From: [REDACTED]
Sent: 02 January 2020 12:08
To: Sian Eggington
Subject: RE: BE/134/19/HH
Attachments: We sent you safe versions of your files; Proposed.pdf
Categories: Green Category

Proposed North Elevation

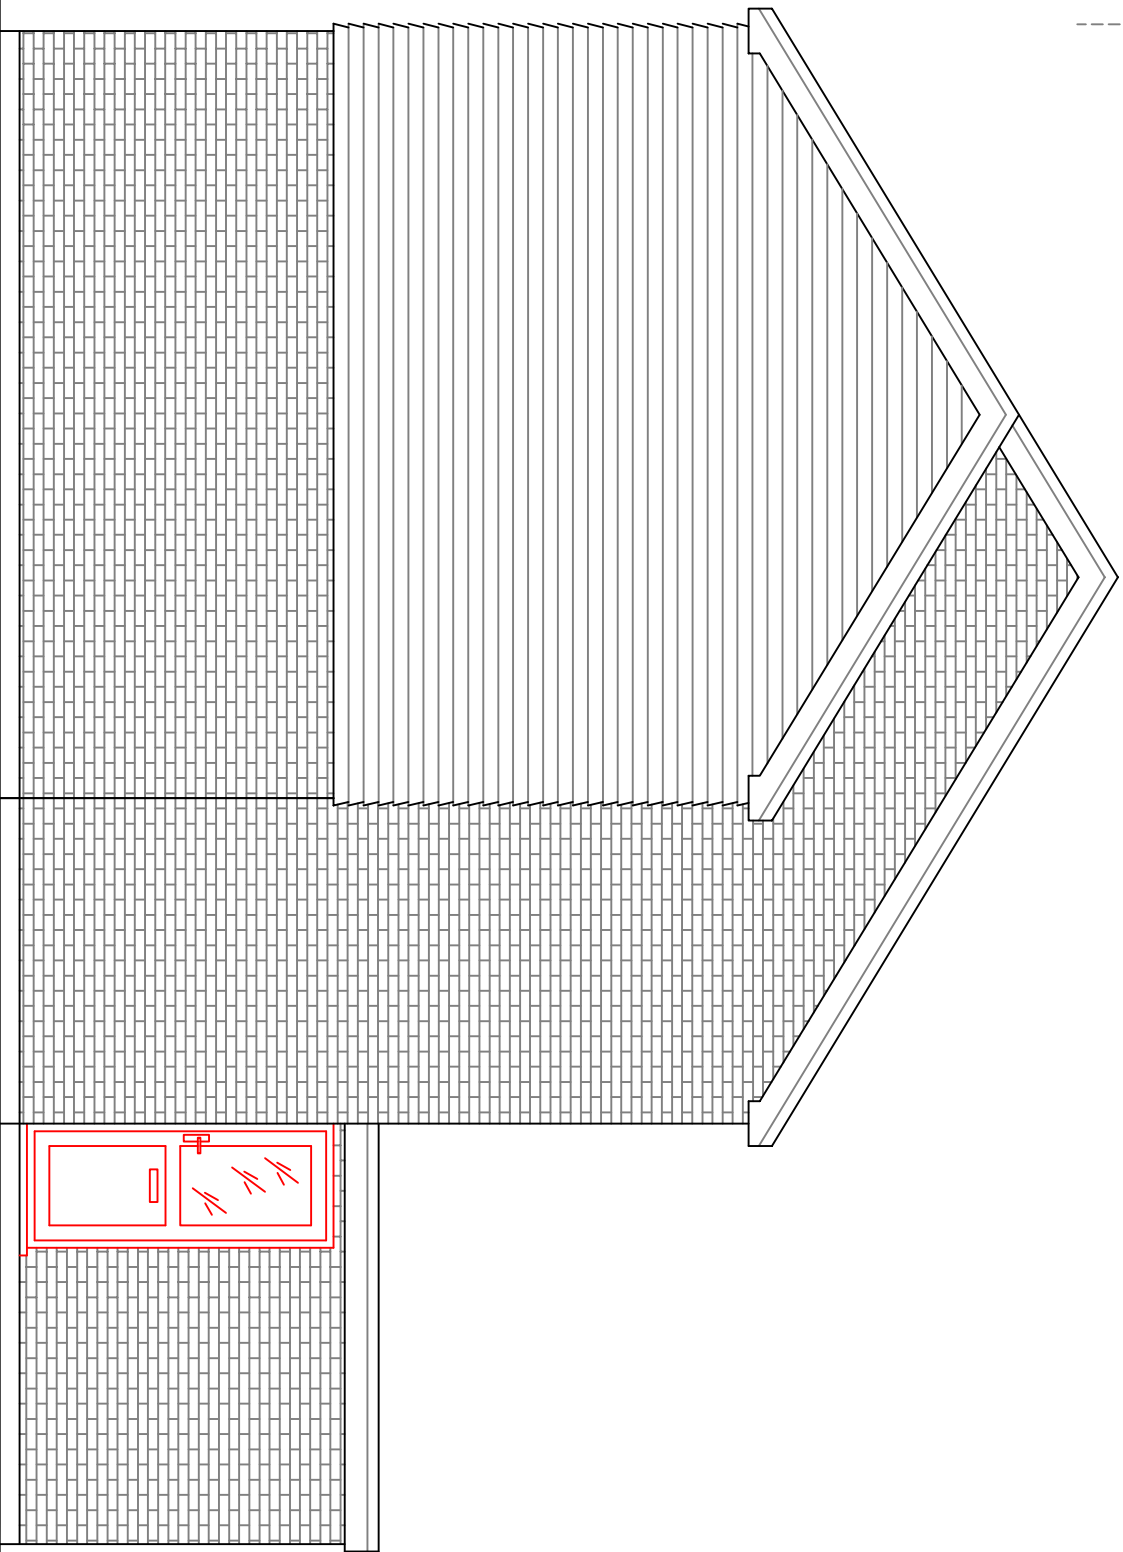
A colleague has also checked this application this morning and has agreed with this inconsistency. The application will remain invalid until it is amended.

The north elevation shows the door entering what would be the garage but the floor plan is showing the door entering the bathroom. Which wouldn't be visible on that elevation.

The door on the proposed north elevation is in the wrong position in relation to the proposed ground floor plan. The position the door is in wouldn't be seen on the elevation as its opening from the bathroom outwards not the garage outwards.

Please see attached plan with the door and opening marked in red, showing the front door opening into the hallway not the garage

It's the front door to the house? It's shown opening inward on plan it's quite correct
